Ribble Valley Borough Council

App no: 26.0159

Address: Land off Shire Lane (adj Shire Lane House) Hurst Green

Proposal: Permission in principle for up to 3 no. self-build dwellings to include 1 no. bungalow for over 55's.

SITE LOCATION PLAN  
AREA 2 HA  
SCALE: 1:1250 on A4  
CENTRE COORDINATES: 367832 437990

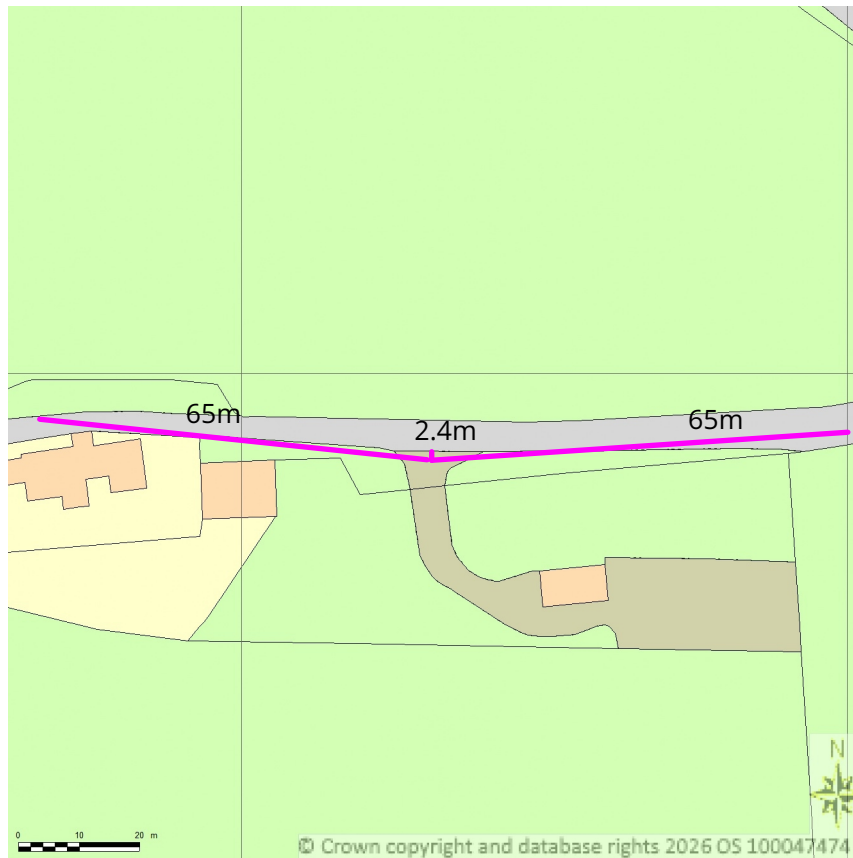
Shire Lane joins Longridge Road to the west of the site and the junction is considered to be sub-standard for visibility splays and width and lies at an acute angle resulting in difficulties arising for drivers emerging and entering safely. Longridge Road is classified B6243 and is subject to a 40mph speed limit. Any collisions are likely to result in serious injuries as demonstrated by the two collisions, recorded in the previous 5 years, on Longridge Road within 600m to the west of the junction.

Shire Lane also joins Longridge Road to the east of the site, adjacent to St. John's Church, and there are similar concerns with a narrow carriageway width and sub-standard visibility splays.

The highway network is not considered suitable to accommodate the intensification of use from the proposed development due to the narrow carriageway width without sufficient passing places and the sub-standard junction arrangements at both junctions onto the classified road network. Subsequently there is considered to be a detrimental impact upon highway users as a result.
